WEST SUSSEX COUNTY COUNCIL CONSULTATION

TO:	Arun District Council FAO: Simon Davis
FROM:	Stephen Gee WSCC – Highways Authority
DATE:	22 July 2026
LOCATION:	Land East of Wandleys Lane Fontwell
SUBJECT:	WA/51/26/RES Approval of reserved matters following the grant of outline planning permission WA/35/23/OUT, for the construction of 95 No. new homes, access, new pedestrian and cycle links, open space, landscaping, habitat creation, drainage features and associated groundworks and infrastructure, including details relating to the Sensitive Lighting Strategy, POS details and Part M Compliance. This application is in CIL Zone 3 and is CIL Liable as new dwellings.
DATE OF SITE VISIT:	n/a
RECOMMENDATION:	More Information

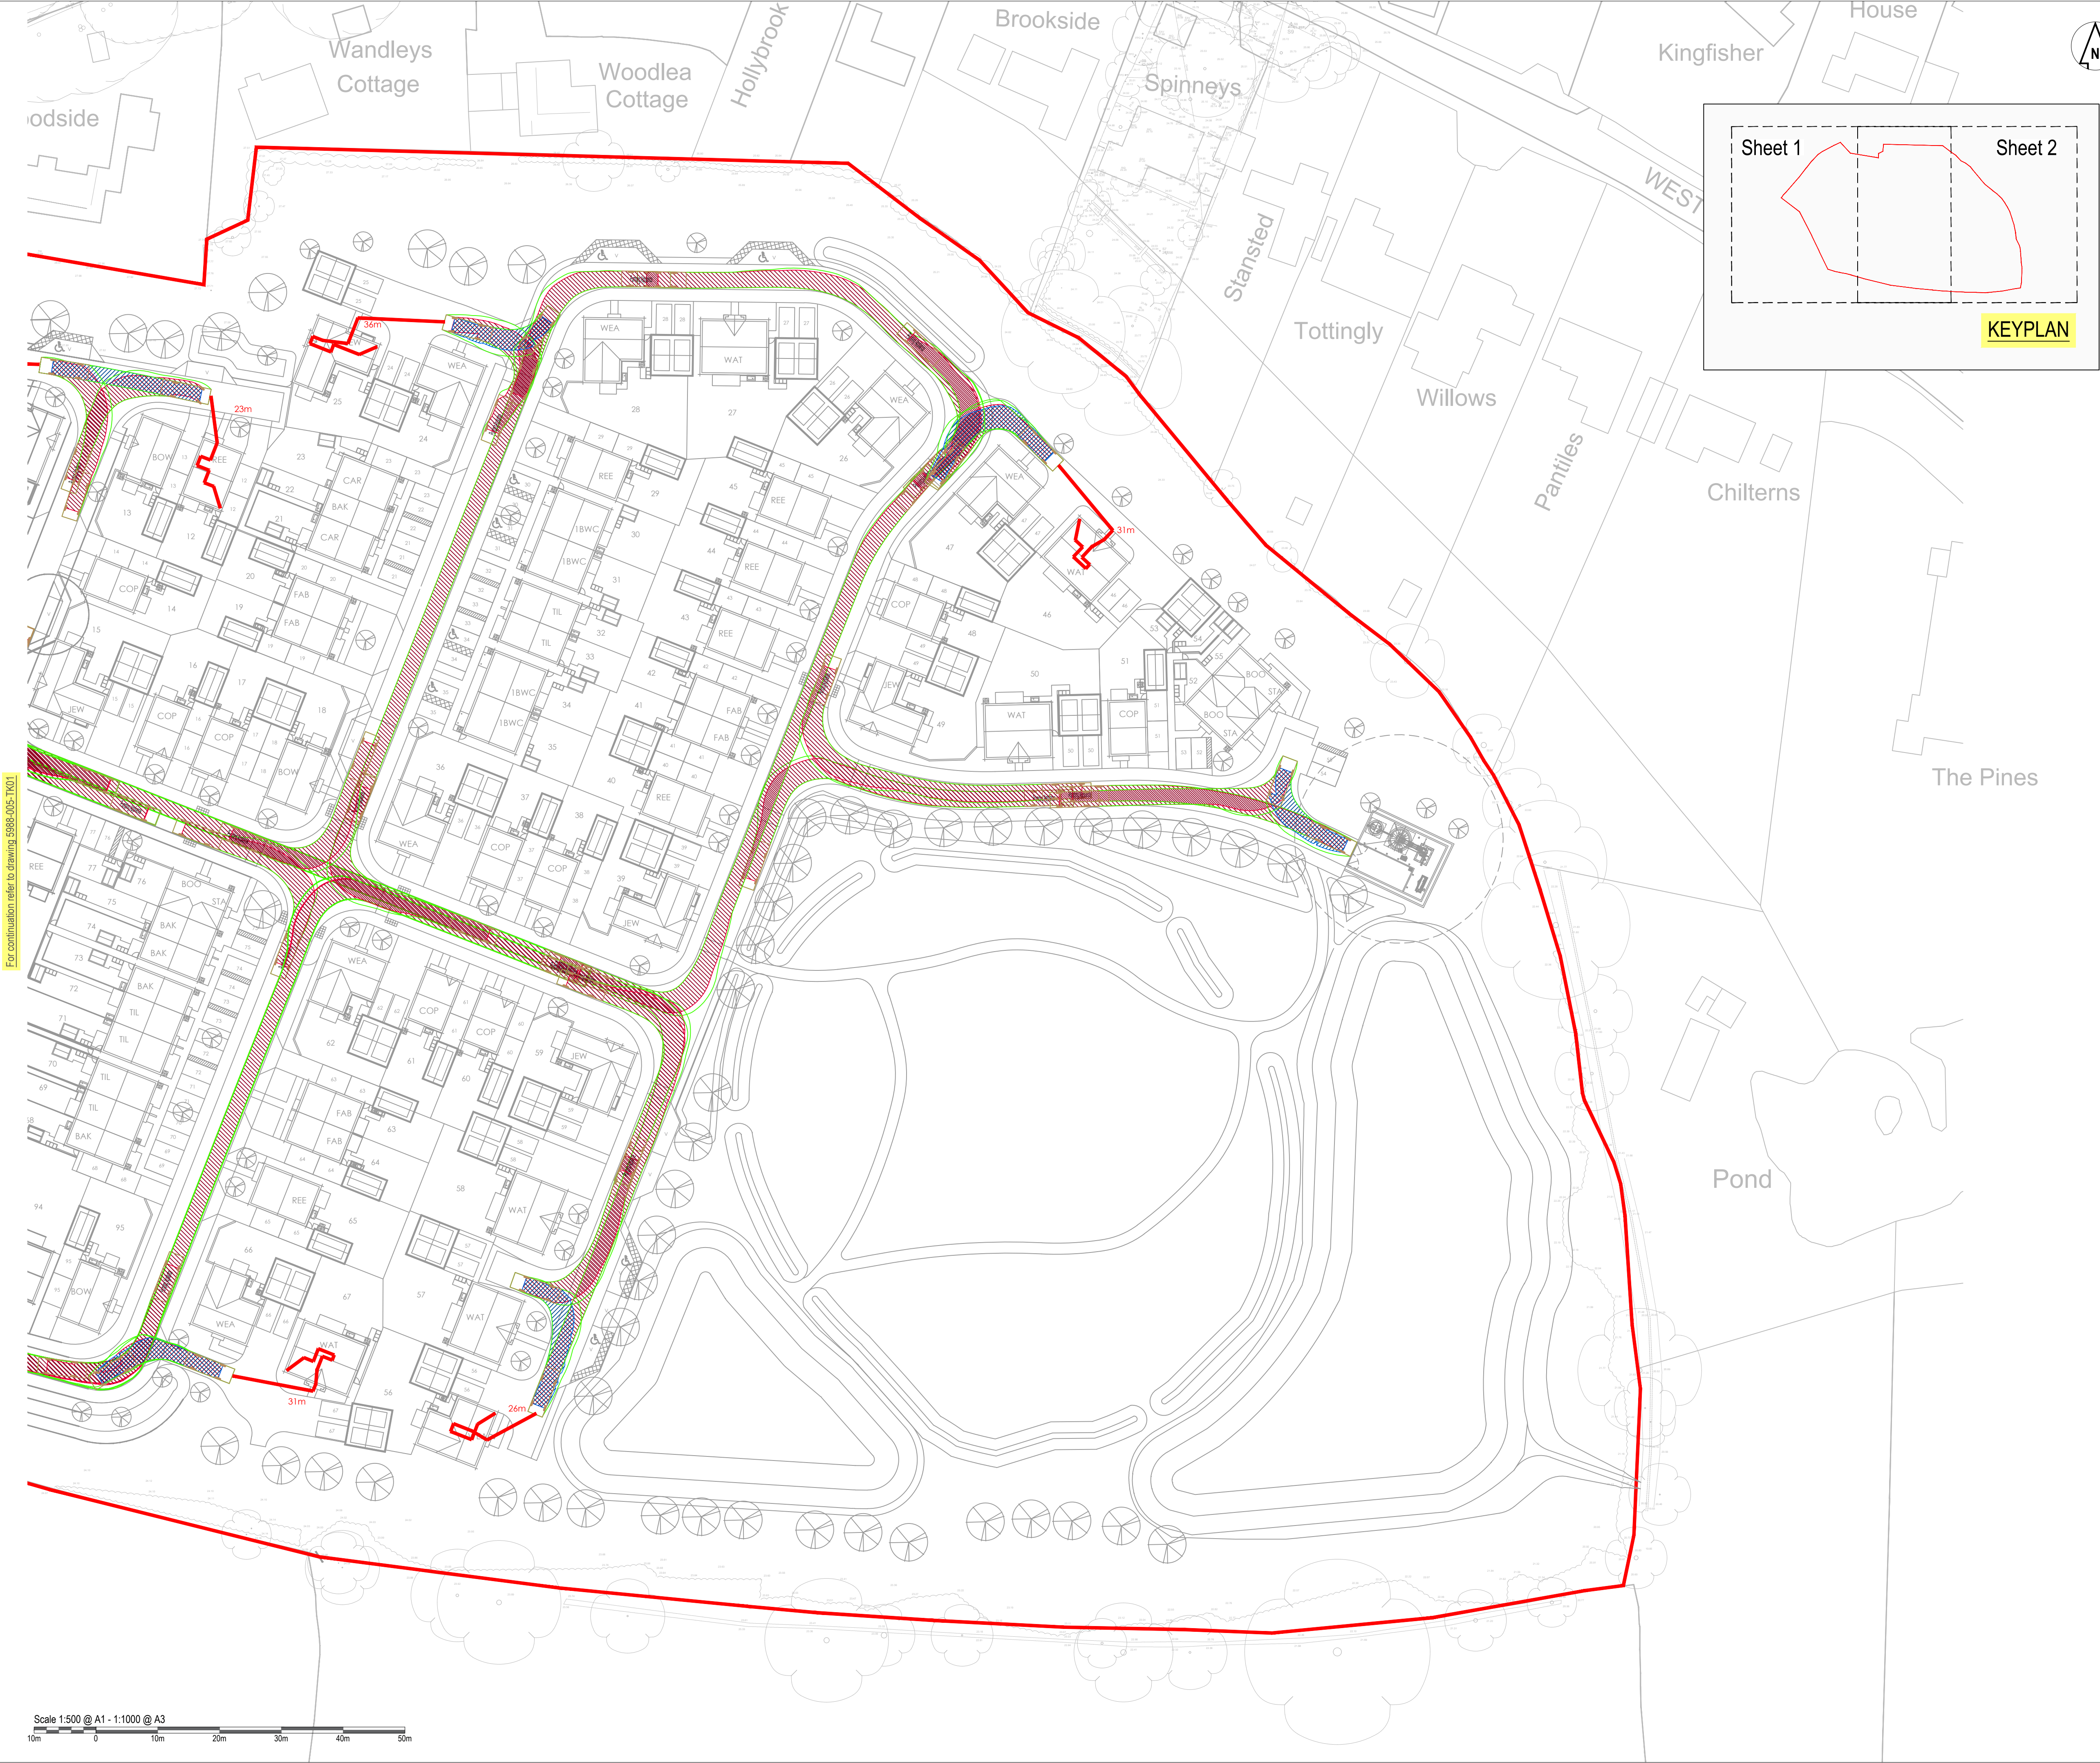
Tracking has been provided for a refuse vehicle and fire tender and is acceptable.

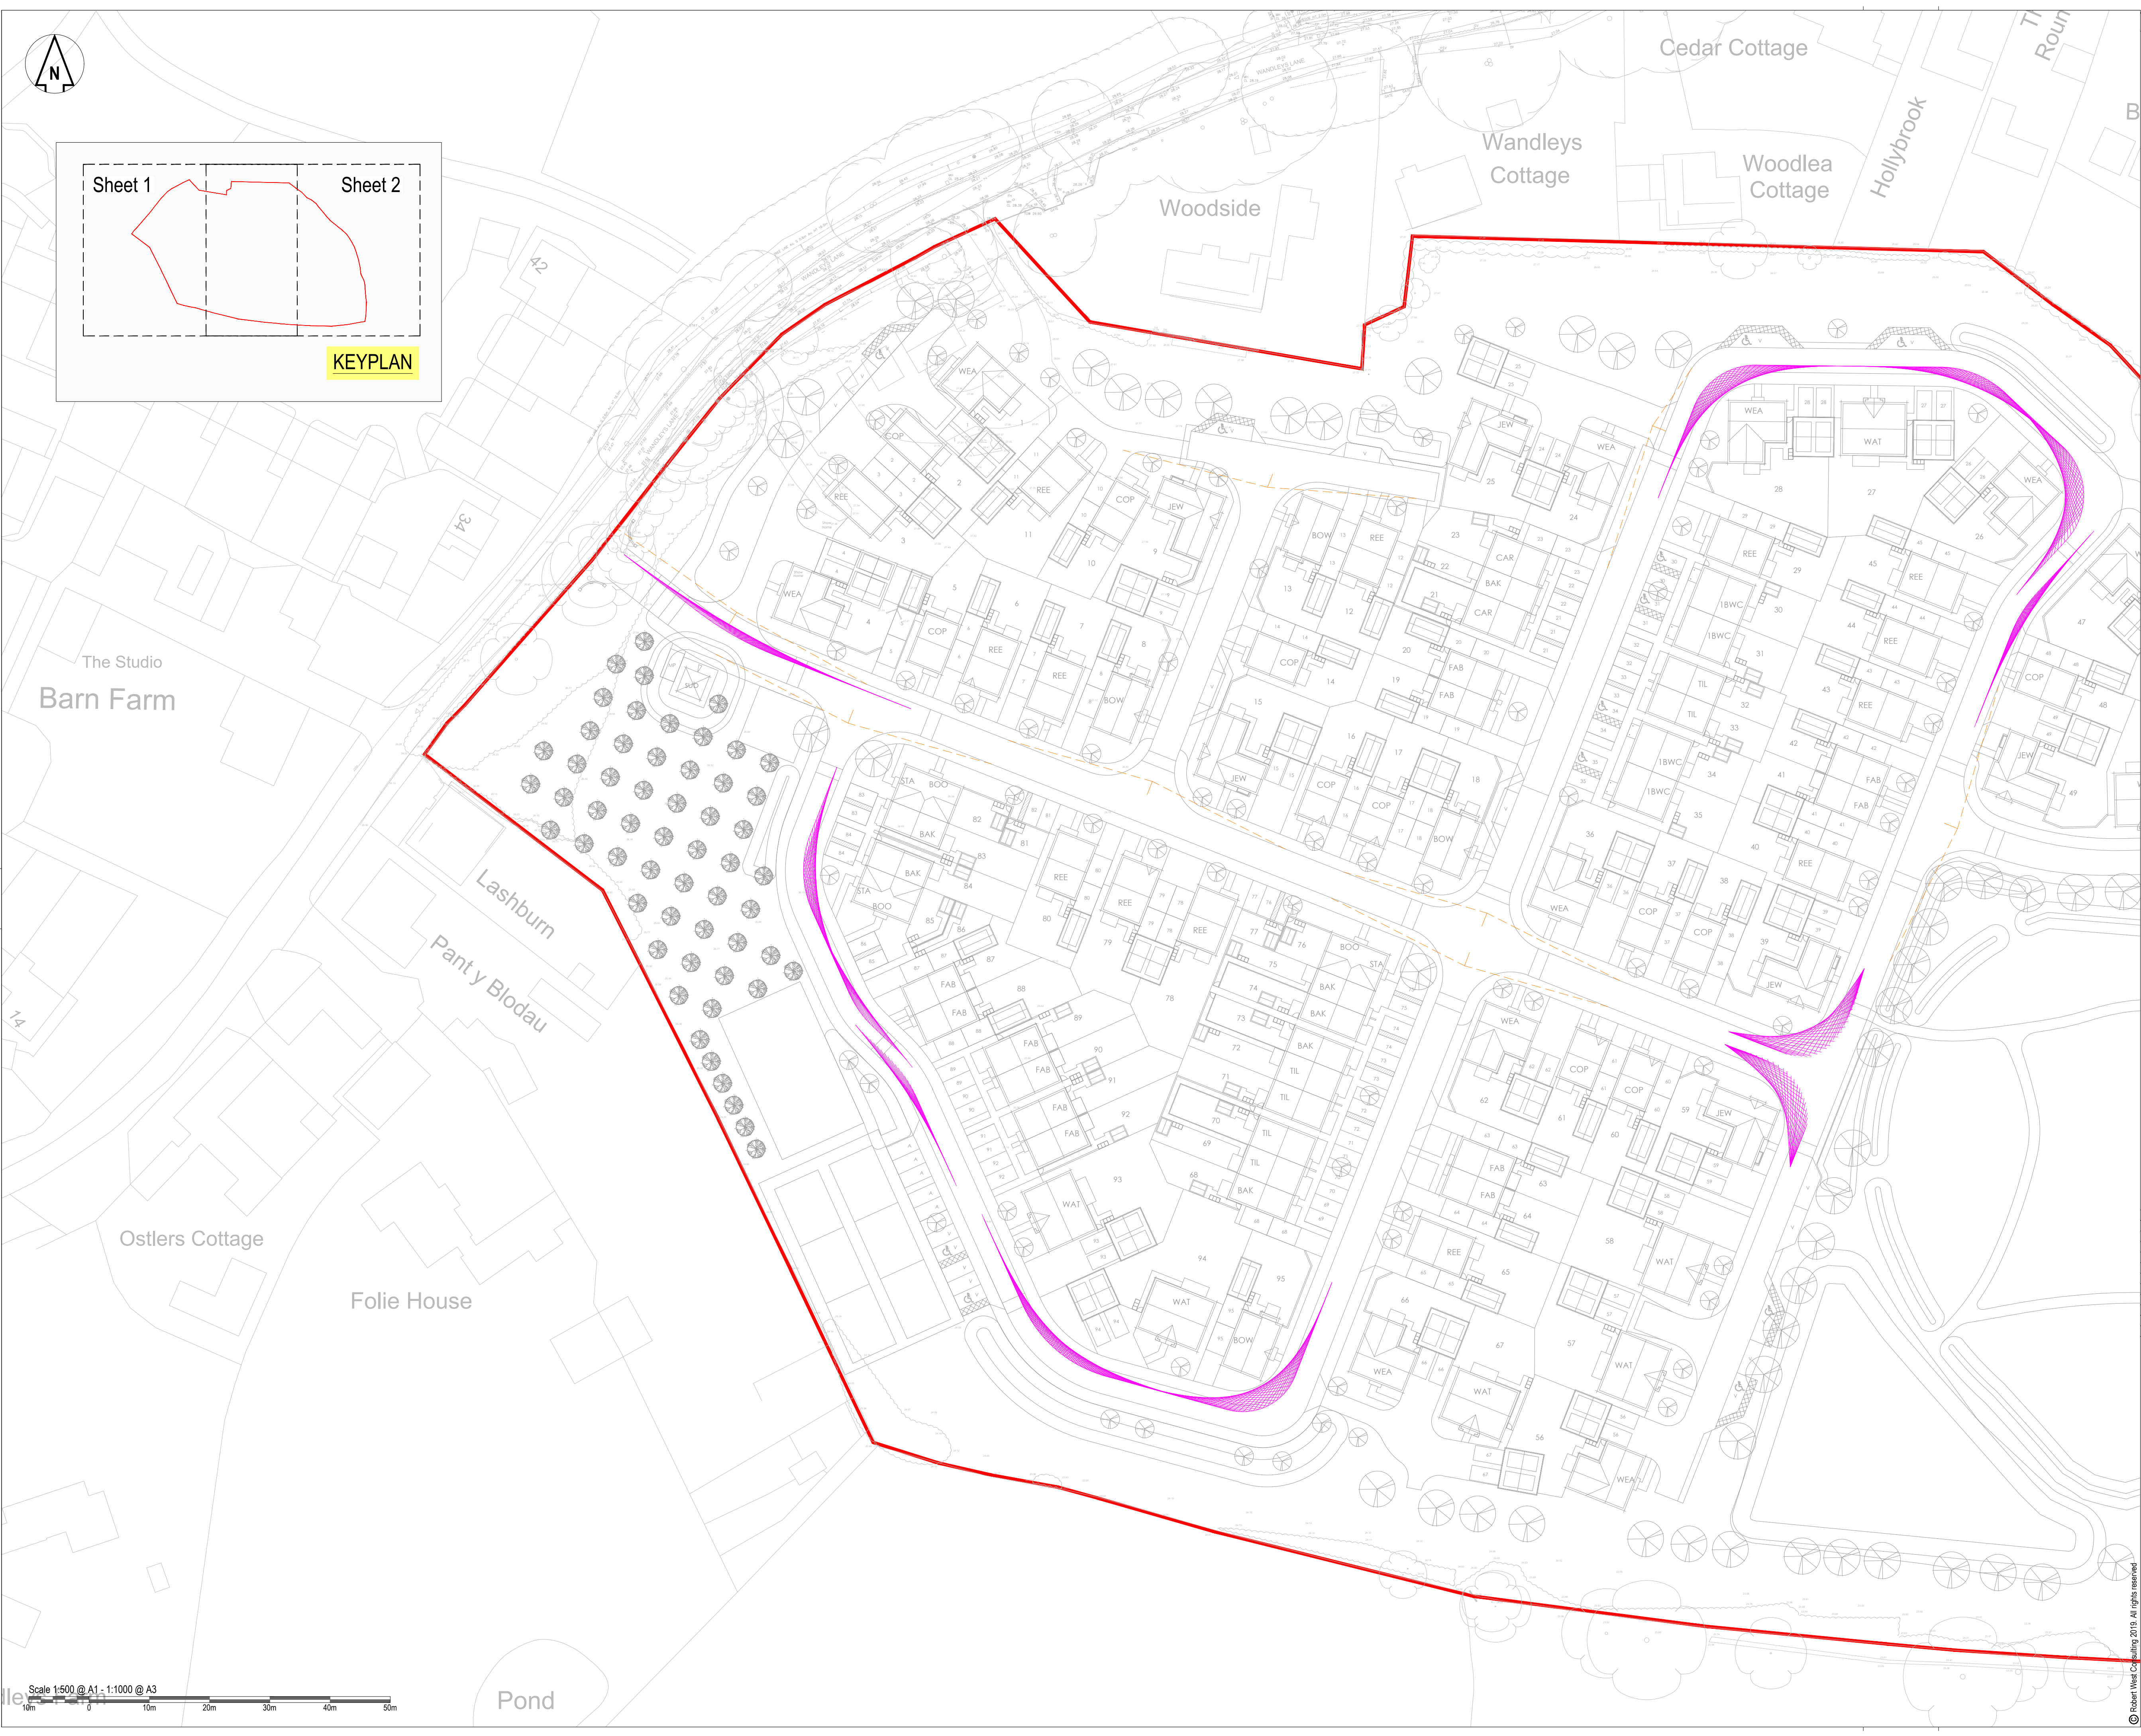
Details should be provided of the design speed on the internal network and junction visibility and forward visibility around bends provided. The impact of the proposed trees on the splays should be considered (and confirmation provided if they are clear stem varieties).
